From
The Member-Secretary
Chennai Metropolitan Develop-
ment Authority
1, Gandhi Irwin Road
Egmore, Chennai 600 008

Letter No. A2/38764/2004

Sub: CMDA - Planning Permission - Construction of Ground floor + First Floor with 2 dwelling units of Residential building at Plot No.B & D in S.NO.111/2, 3, Eswaran Nagar 2nd Street, Pammal village - Development charges and other charges to be remitted - Reg.

SECTION ON 'AB'

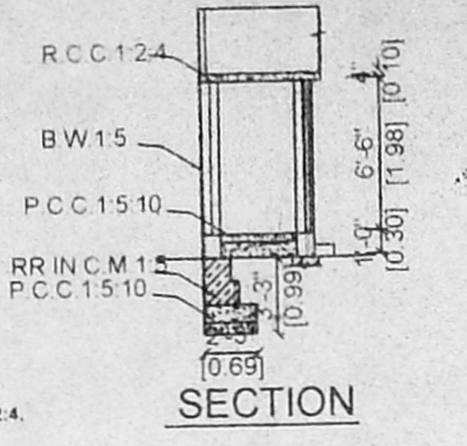
- a. Rain Water conservation Regulations stipulated by CMDA should be adhered to strictly.
- b. Five copies of revised plan as on site condition and site boundary measurements with reference to document
- c. Basement height of 0.90 to be shown.
